**179-B-50**

**#10-79900003**

**Brentwood Street**

**Community Garden (Evergreen Cemetery)**

**CONSTRUCTION SCHEDULE**

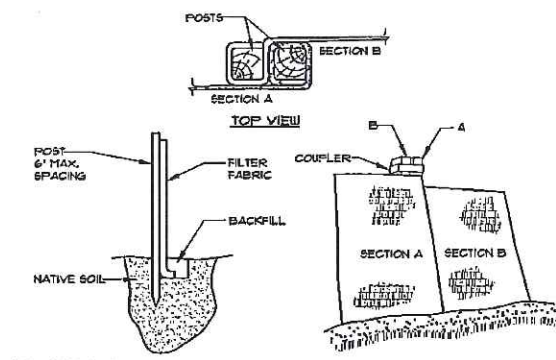
One item I saw missing from the submittal was a project schedule estimating start and stop dates of the drainage and buffer work.

**RIPRAP SWALE**  
NOT TO SCALE

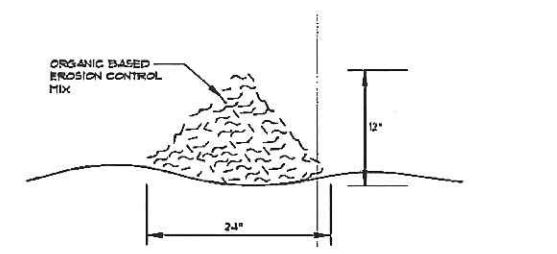
The plans proposed for the site by DCNA show a grass drainage swale being constructed behind the properties at 178 Brentwood, 98 Hamblet, and our property to address the run off issues. We are not confident this plan will solve the problem. Mr. Saucier notes that additional measures need to be taken along Brentwood Street to prevent the runoff from flowing down the driveway at 178 Brentwood. It is our request that Mr. Saucier's recommendations be incorporated into the overall plan for the site. At a recent DCNA meeting, it was stated that Risbara Bros. has offered to construct whatever drainage measures the City requires for the garden site as an additional donation to the project. Given that DCNA has limited funds and the City's budget is under enormous financial pressure, as reported in recent articles in the Portland Press Herald & Maine Sunday Telegram, it would seem prudent that whatever the City requires and Risbara constructs be a comprehensive fix that will be successful in correcting the current stormwater runoff problems. It is up to the City to review the information DCNA's engineers have provided along with

**PRE-DEVELOPMENT STORMWATER PLAN**  
 OF:  
**BRENTWOOD FARMS COMMUNITY GARDEN**  
 AT EVERGREEN CEMETERY, BRENTWOOD STREET  
 PORTLAND, MAINE  
 FOR:  
**DEERING CENTER NEIGHBORHOOD ASSOC.**  
 14 HILLIS STREET  
 PORTLAND, ME 04103

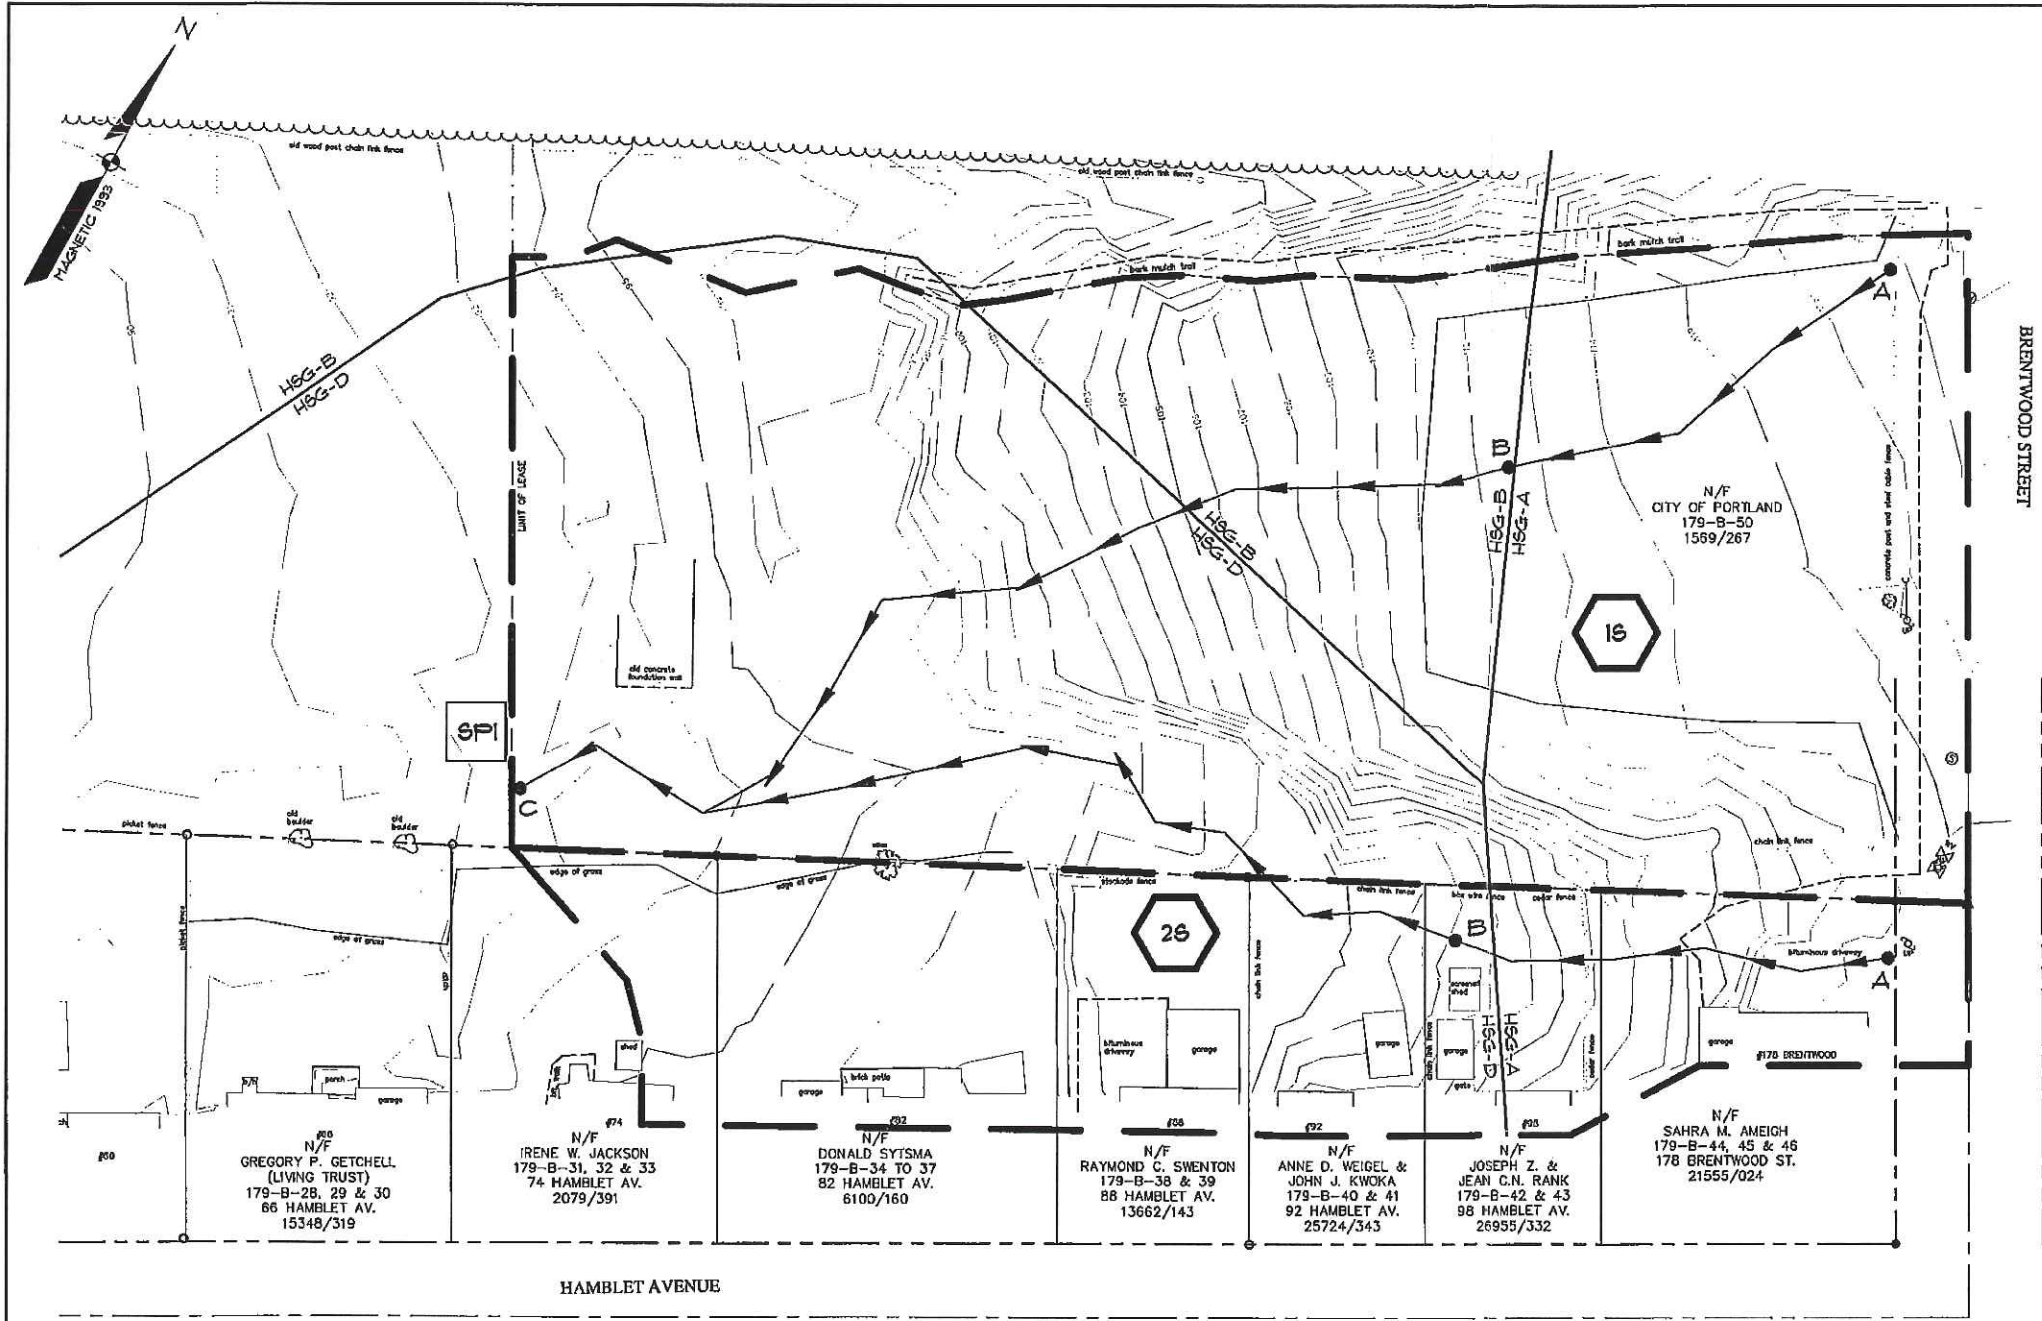
- The Sebago Technics report does not address whether or not the development has impacted our property. In fact, the study utilized an analysis point 250 feet downgrade from our property.
- There are a number of flaws in the analysis which may render the conclusions invalid.

- There is no indication in the report that Sebago Technics (ST) made visits to the site to collect data for their analysis during either dry conditions or rain conditions. It would appear all the data that was used originated from published sources.
- The pre and post condition surveys do not offer the same level of detail to provide an accurate pre and post condition analysis.
- The report does not take into account that the trees and brush that were cut down were buried in large pits near our property line and the resulting changes that may have caused in subsurface water flow.

Agree with the issue that they didn't account for fill material. They just used the mapped soil types for the area without confirmation. Also note that they didn't take into account the 12-inches of "well draining soil" they placed onsite. "Well draining" is not a mapped soil type and is subjective to each person. Between the fill material and the unknown of the well draining soil, they should have done Percolation Tests to evaluate actual infiltration rates for the site now.

I also have an issue with the way they looked at the two different areas: the Garden and the Residences. They basically spun everything to make it look like the residences increase in peak discharge would be offset by the decrease in peak discharge from the property changes. While they have every right to evaluate the adjacent residences, they should not have gone back to 1994 info as a "starting point/pre" for the residences since much has changed between then and now. They could do that with the Garden property, but the residential property area should have had an initial/pre point of 2008 or something more recent.
